Your Ref: OWPC22837
Our Ref: R/72/19/PL 02-04-2019
Please ask for:
Mrs A Gardner

Demolition of existing garage & store on existing dwelling & construction of 2 new dwellings in rear garden.

6 Manor Road Rustington

DRAWING: PROPOSED NEW DWELLINGS - PLANS **SCALE:** 1:50 @ A2 **DATE:** 24/04/2019 **DRAWING No:** DS/6MANOR/04 rev 1

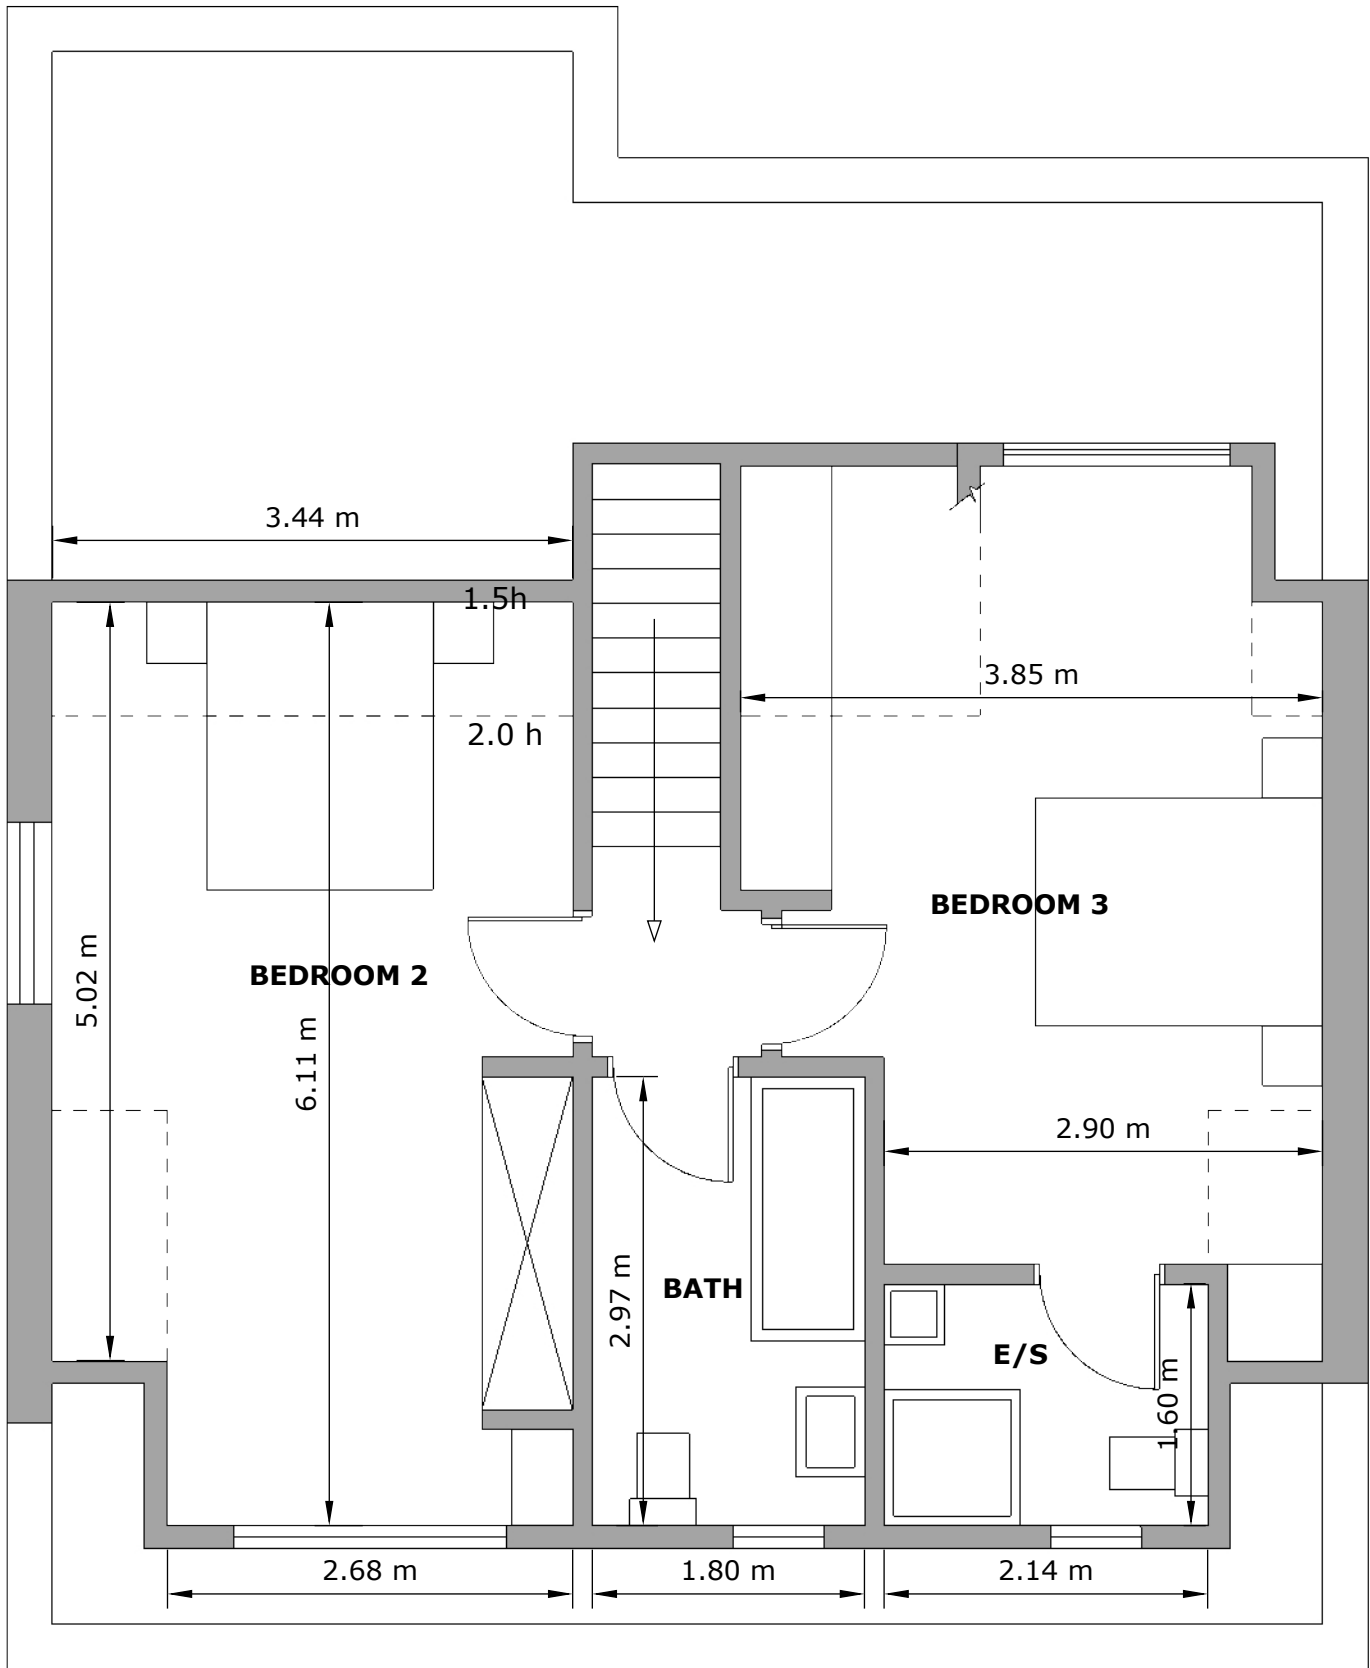
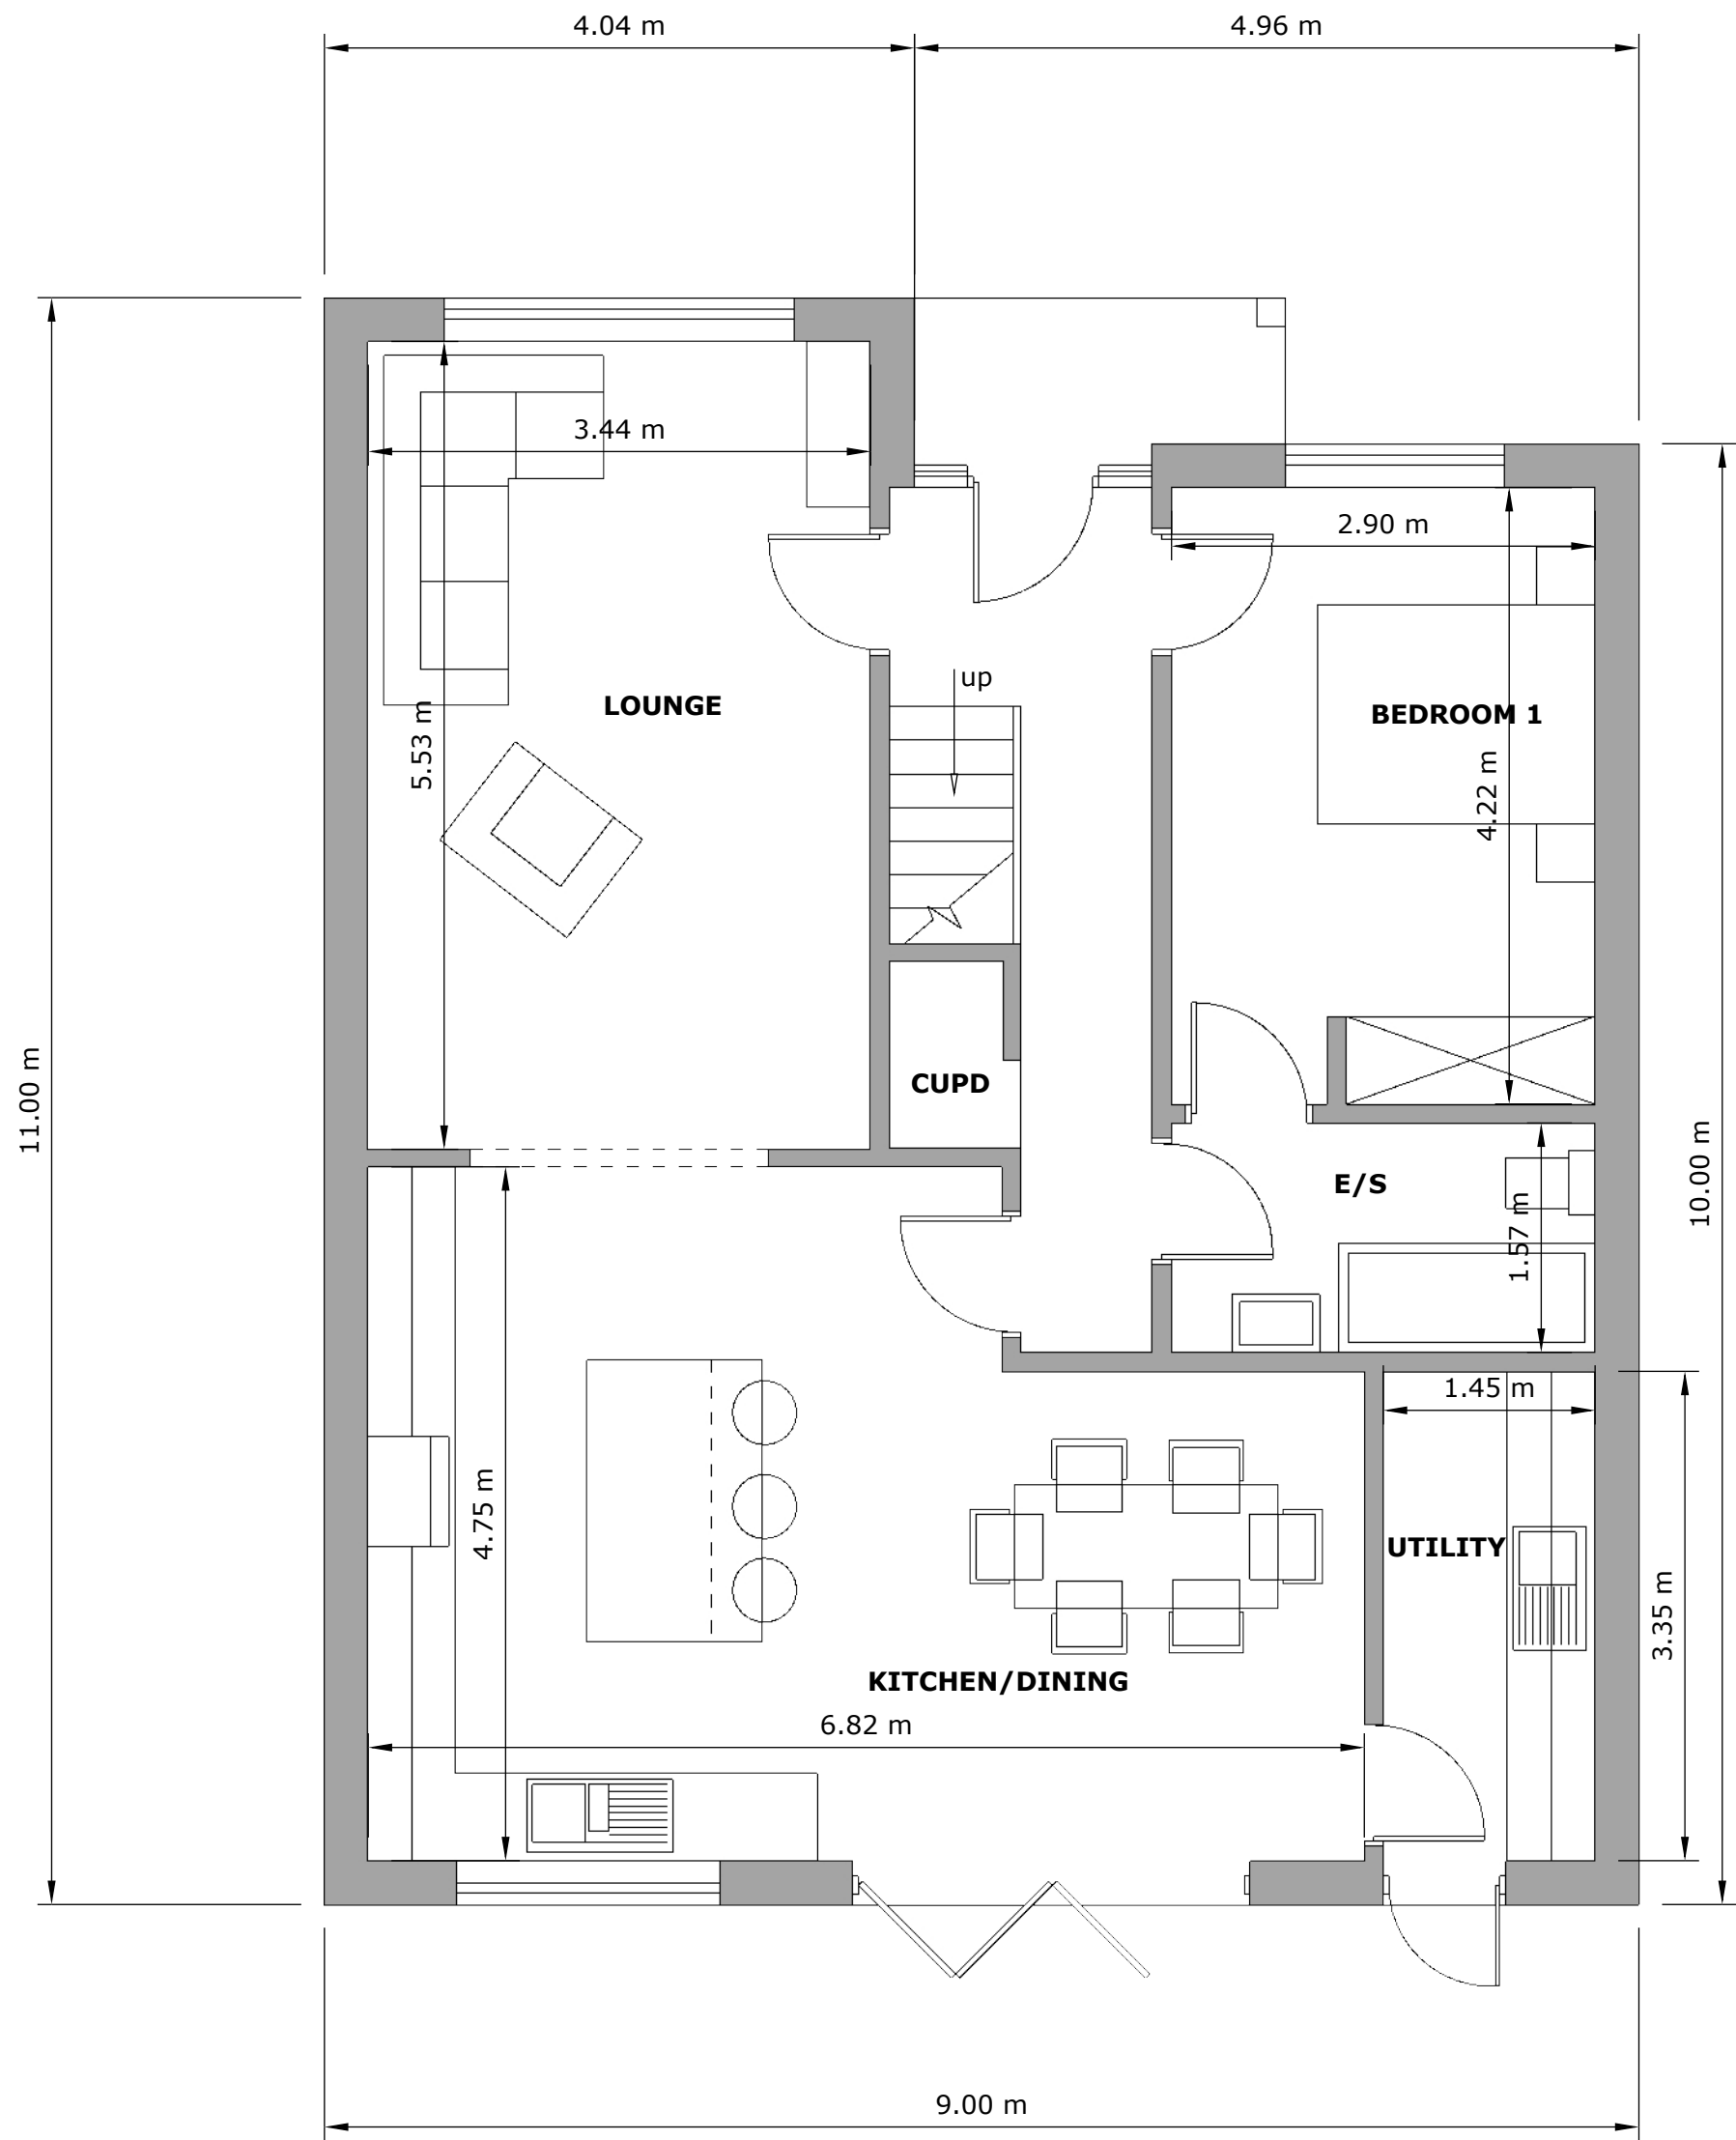
- *The Design and Access Statement, first paragraph (introduction) is referring to a "Generous 4-bedroom detached bungalow with garage to each side", I see neither 4 bedrooms on the plan view or facility for a garage or reference to a bungalow*

DRAWING No: DS/6MANOR/03 rev 1

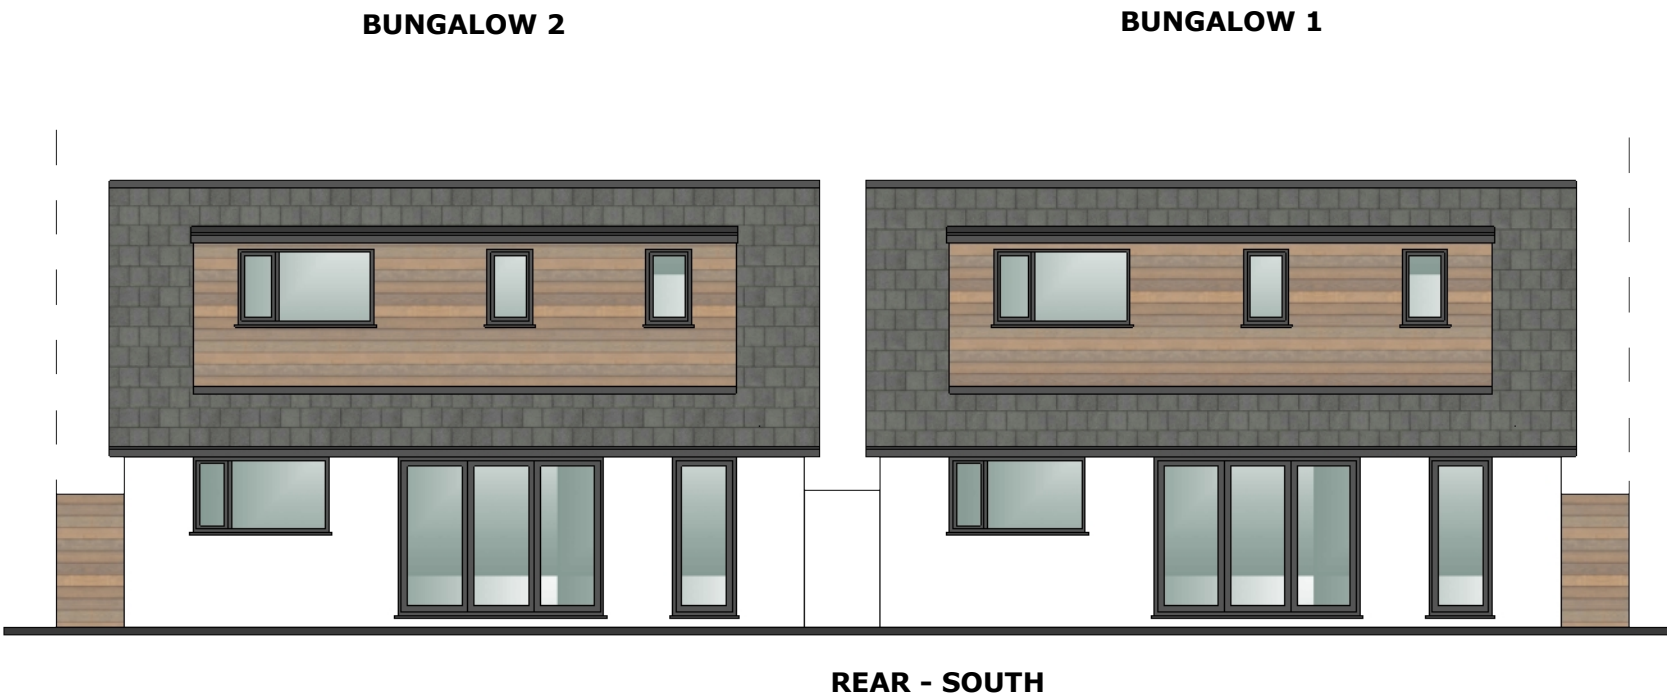
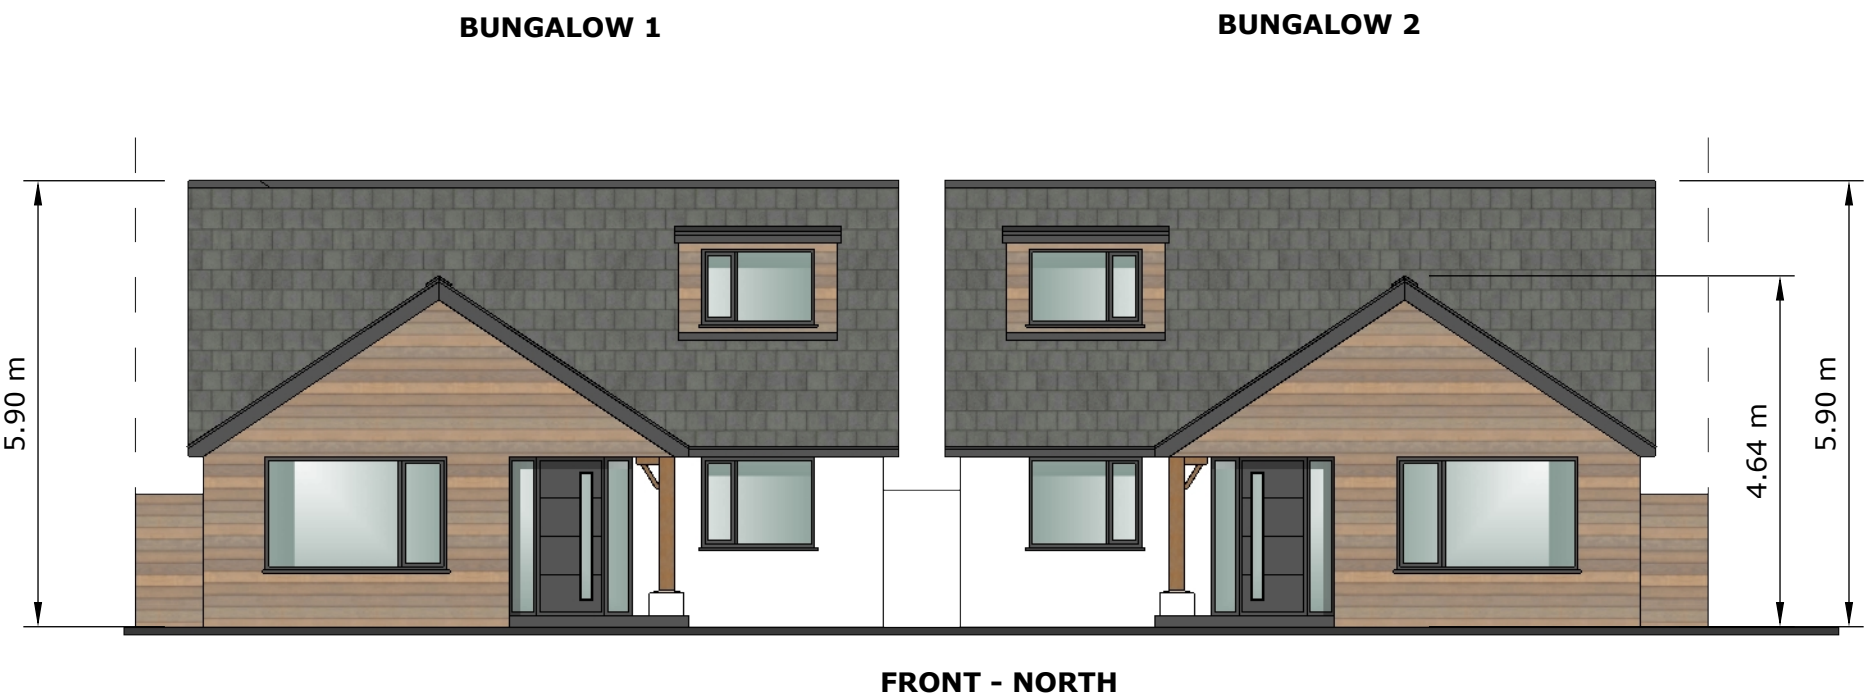
- *The Elevation Street Scene does not accurately reflect the true ridge height of the proposed dwellings, even though the new ridge height is 5.9m that is still a differential of 0.95m higher than the existing building line of numbers 2,3 and 4 Grafton Close, still not sympathetically keeping in context with the surrounding existing dwellings and environment*
